## SPR EA1N and EA2 PROJECTS

### DEADLINE 2 - COMMENTS ON PUBLIC RIGHTS OF WAY CLARIFICATION NOTE

Interested Party: SASES PINS Refs: 20024106 & 20024110

Figure: 29.37e
Viewpoint 5: Public Right of Way, near Moor Farm

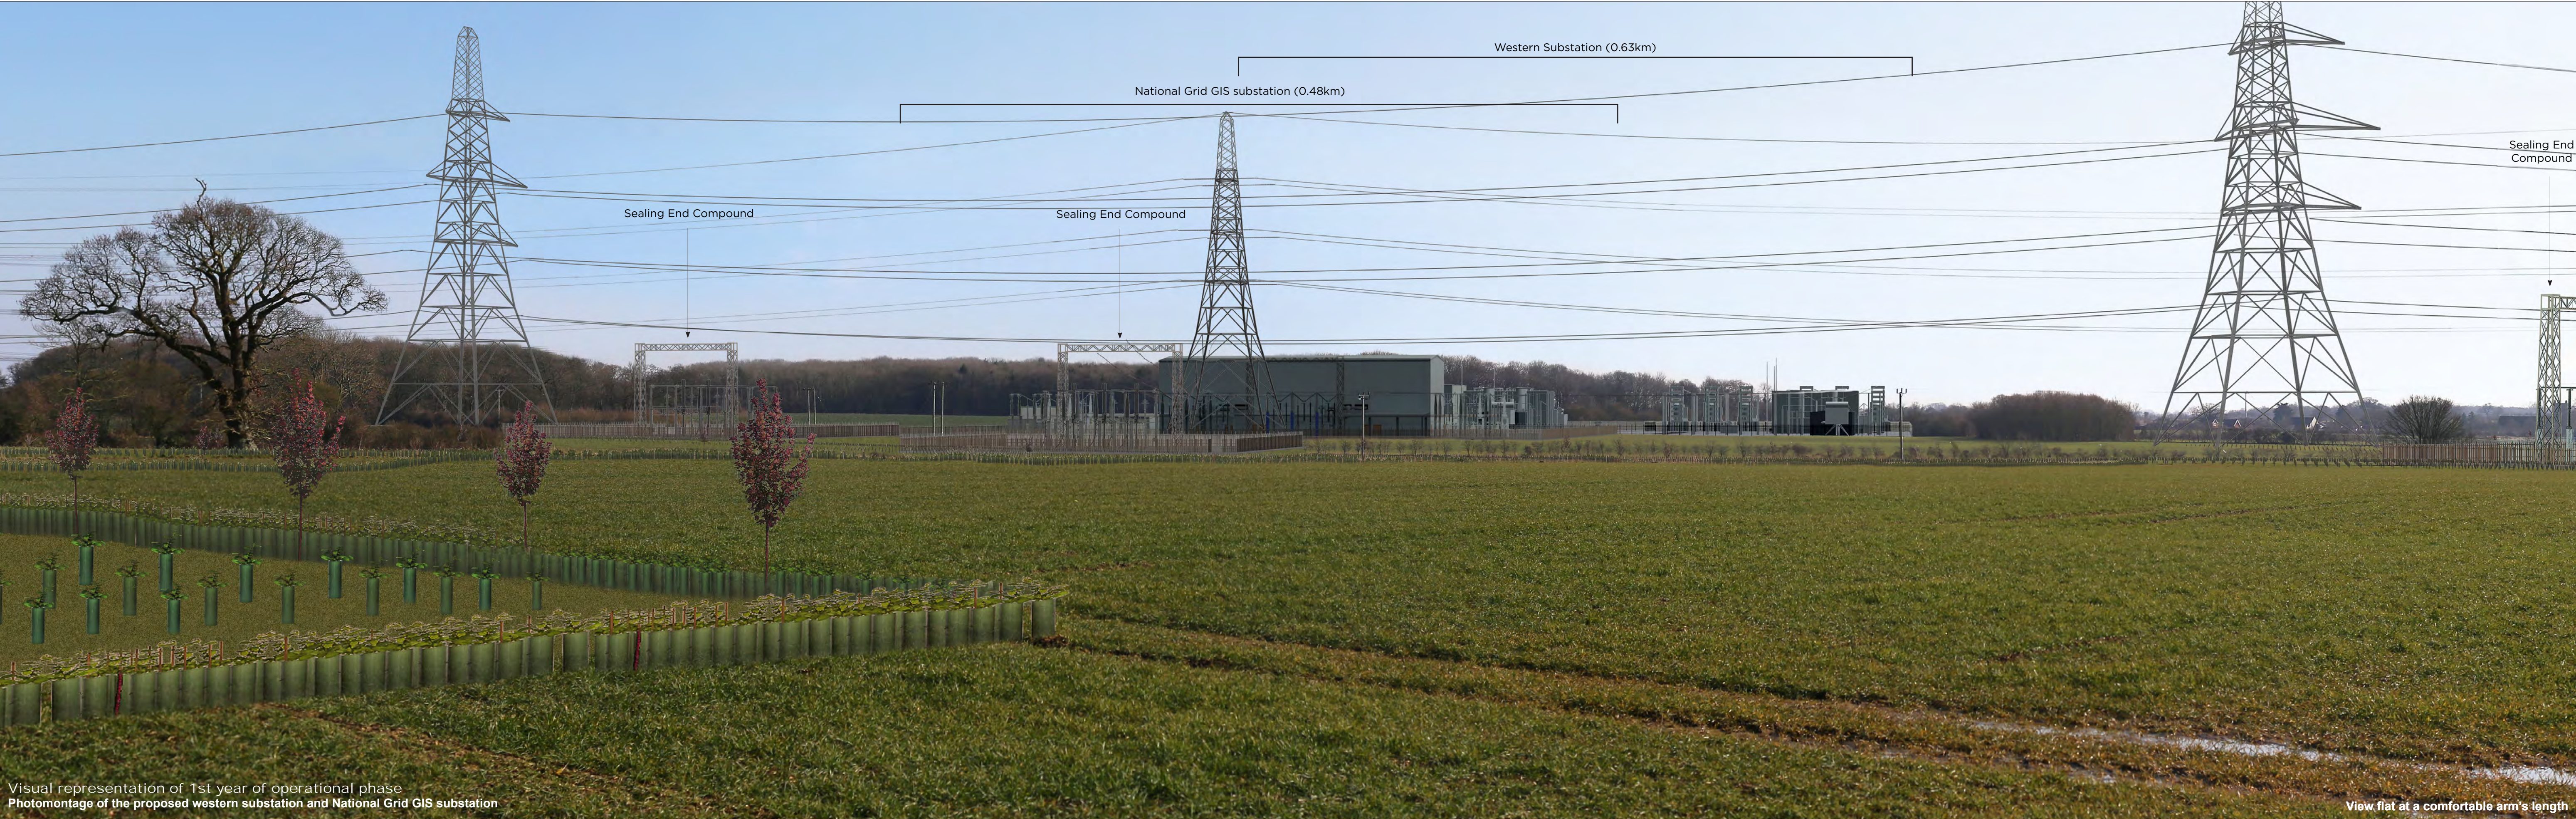
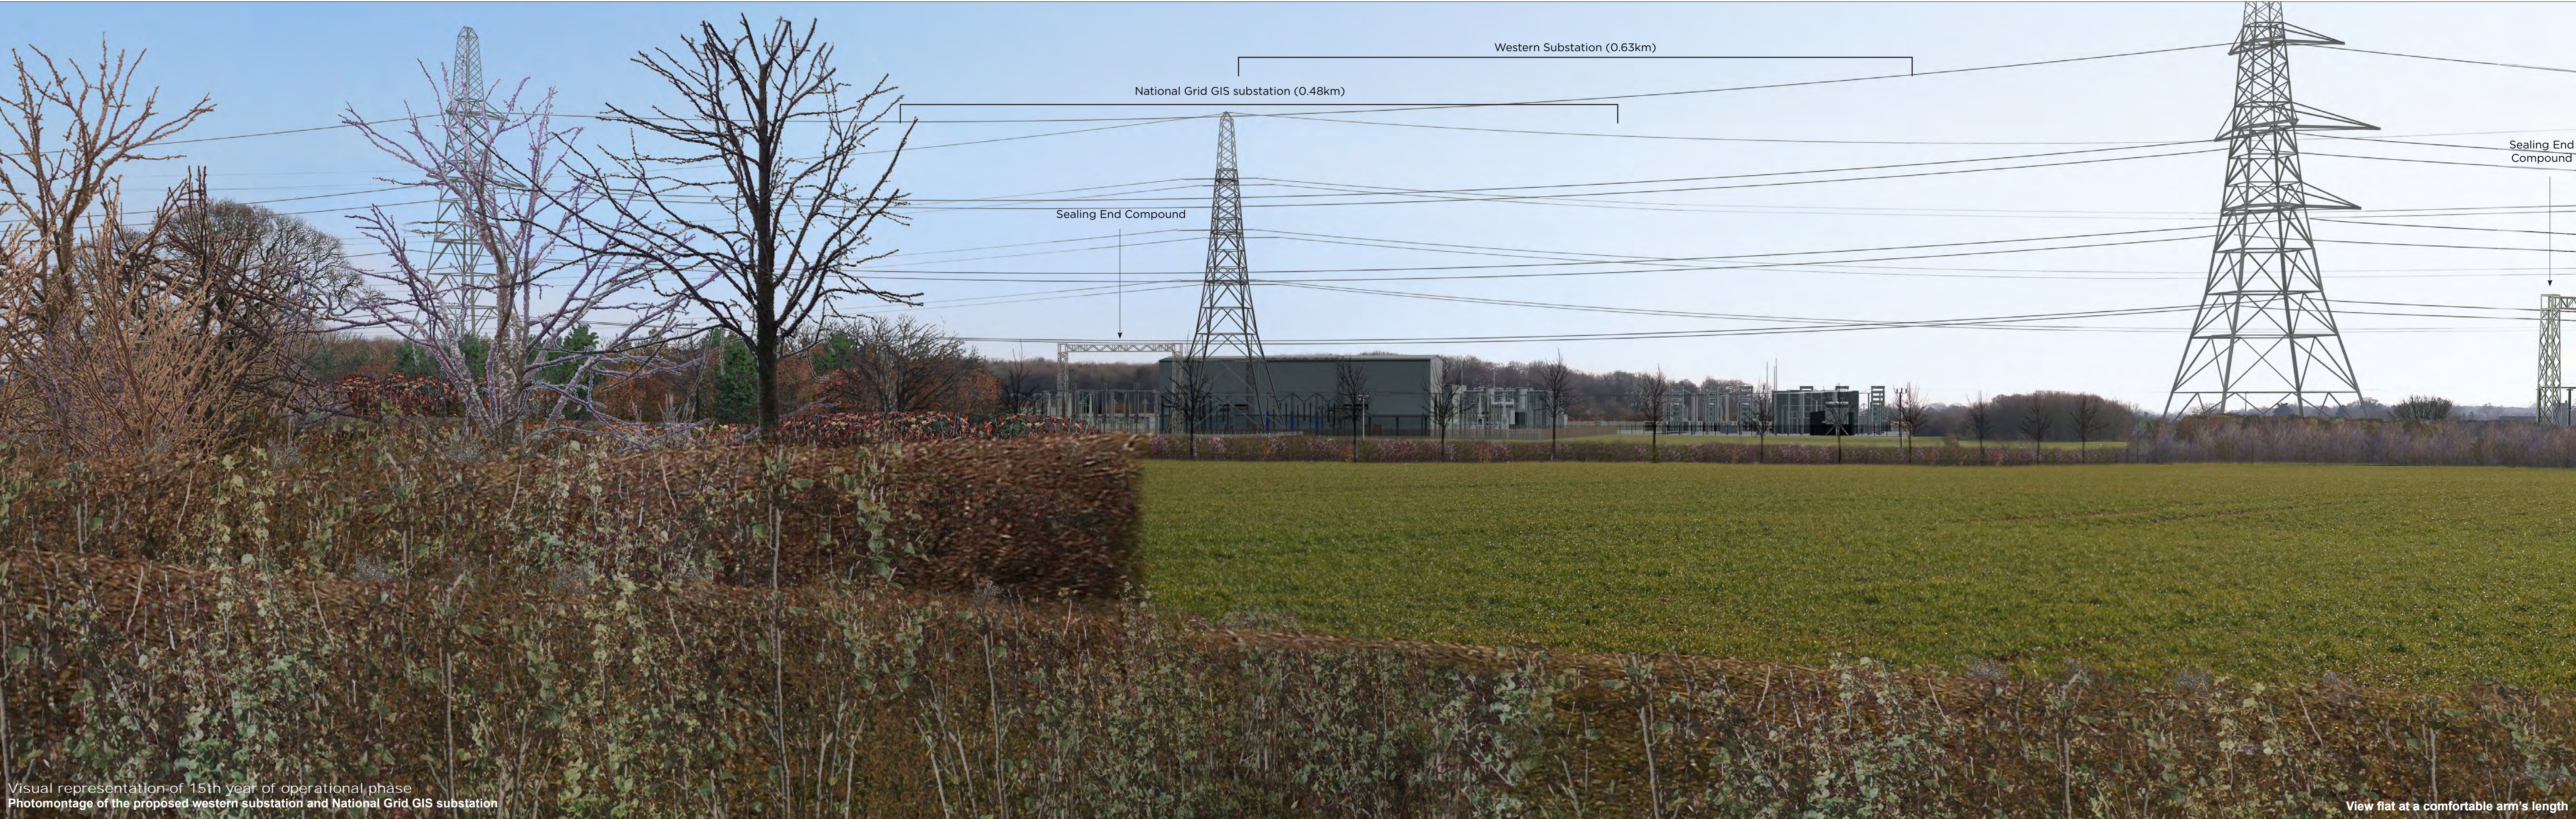
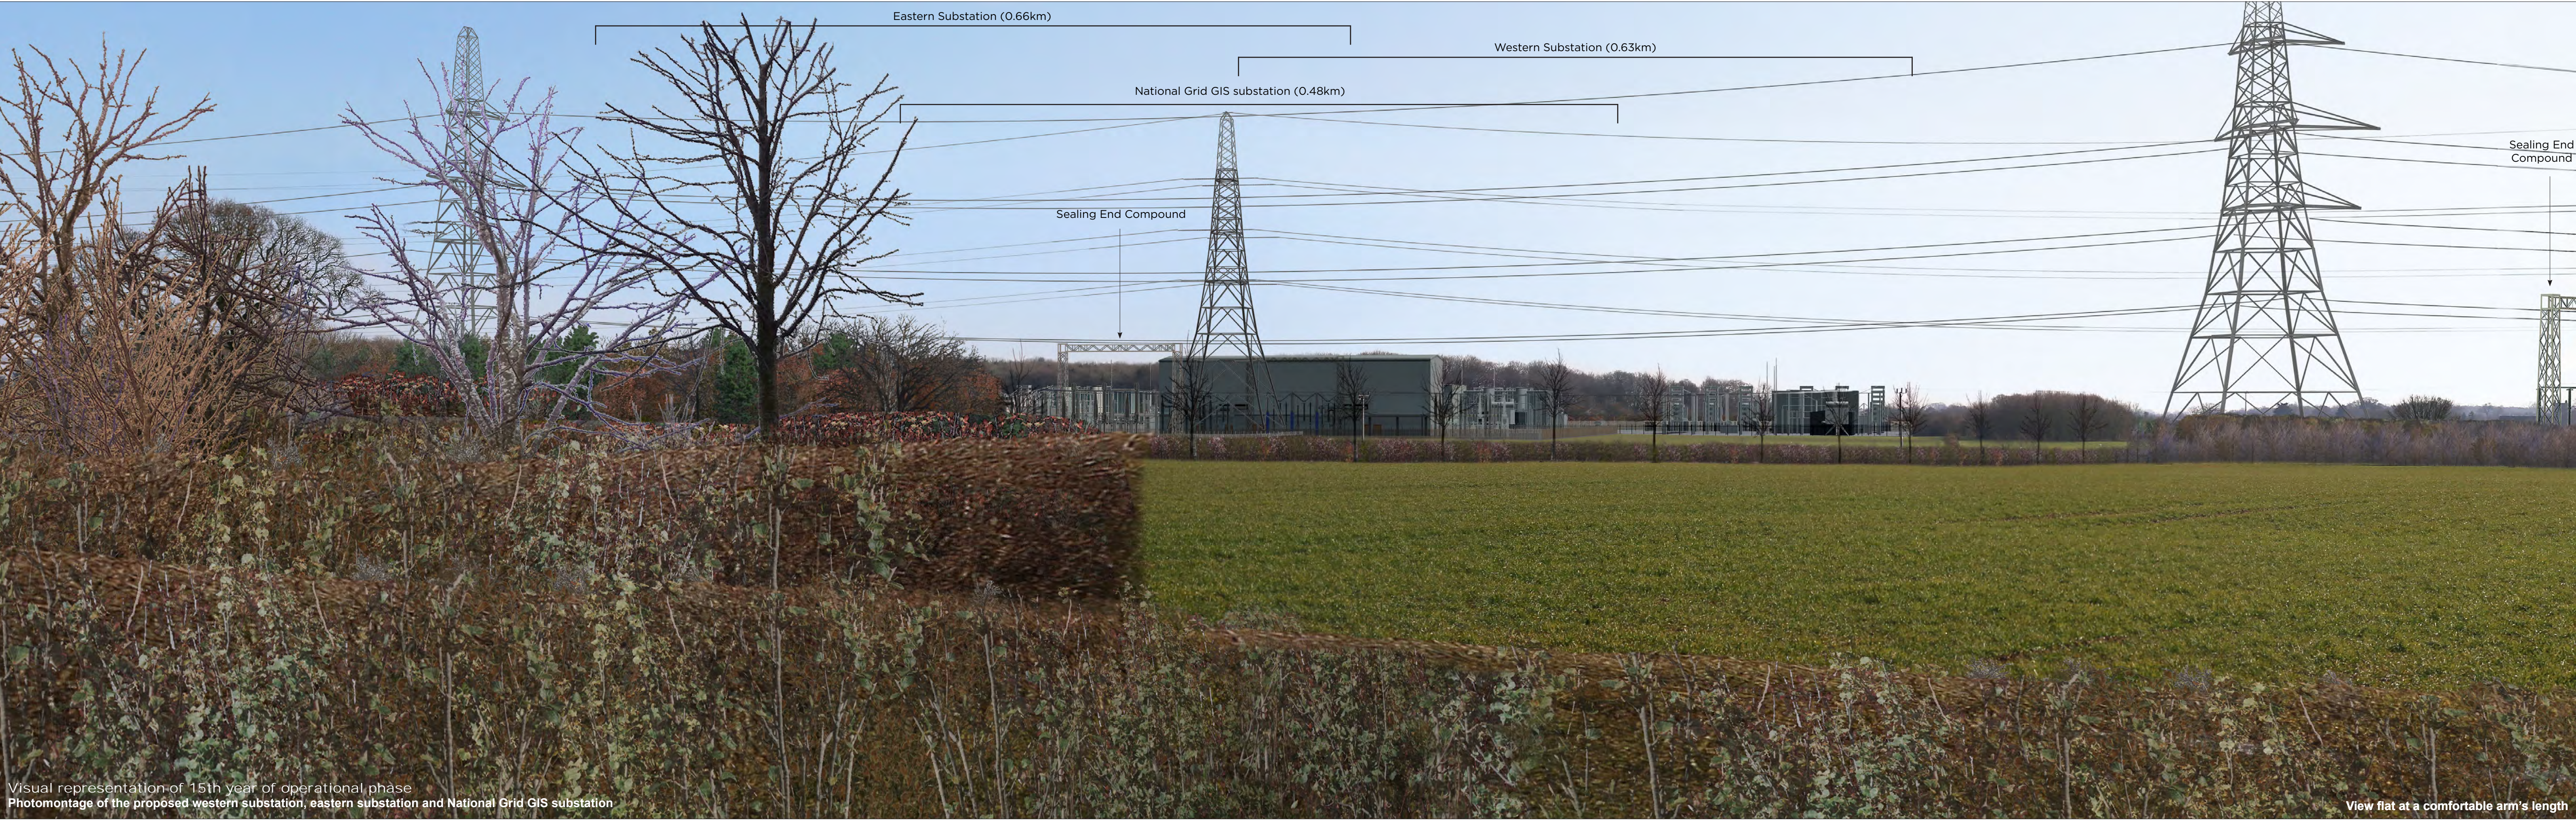
visualisations of 3 viewpoints on the existing footpaths requested by the ExA in their First Written Questions.
Page 16 – 18 LVIA	Onshore Cable Route  Onshore Substation	<p>The Applicant acknowledges significant impacts on views on the Sandlings Walk but has failed to address the significance of its proposed use of the Sandlings Walk (FP2 heading east from Grove Road) as a pre-construction access. This is a serious Health &amp; Safety issue which must be dealt with.</p> <p>The Applicant acknowledges that there will be significant visual effects on people walking to the north of Friston between Friston and Fristonmoor. The Applicant has however not explained how it will keep this route open, given that FP17 crosses the proposed permanent access road and is subject to Temporary Occupation and Rights for drainage from the proposed SuDs basins.</p> <p>The Applicant relies on over-optimistic growth rates of planting to reduce the impacts on the PRoW network. See Jon Rose Associates report submitted by SASES at Deadline 1. Viewpoint 2 near Church Road however shows there will be significant visual effects even after 15 years of optimistic growth.</p>
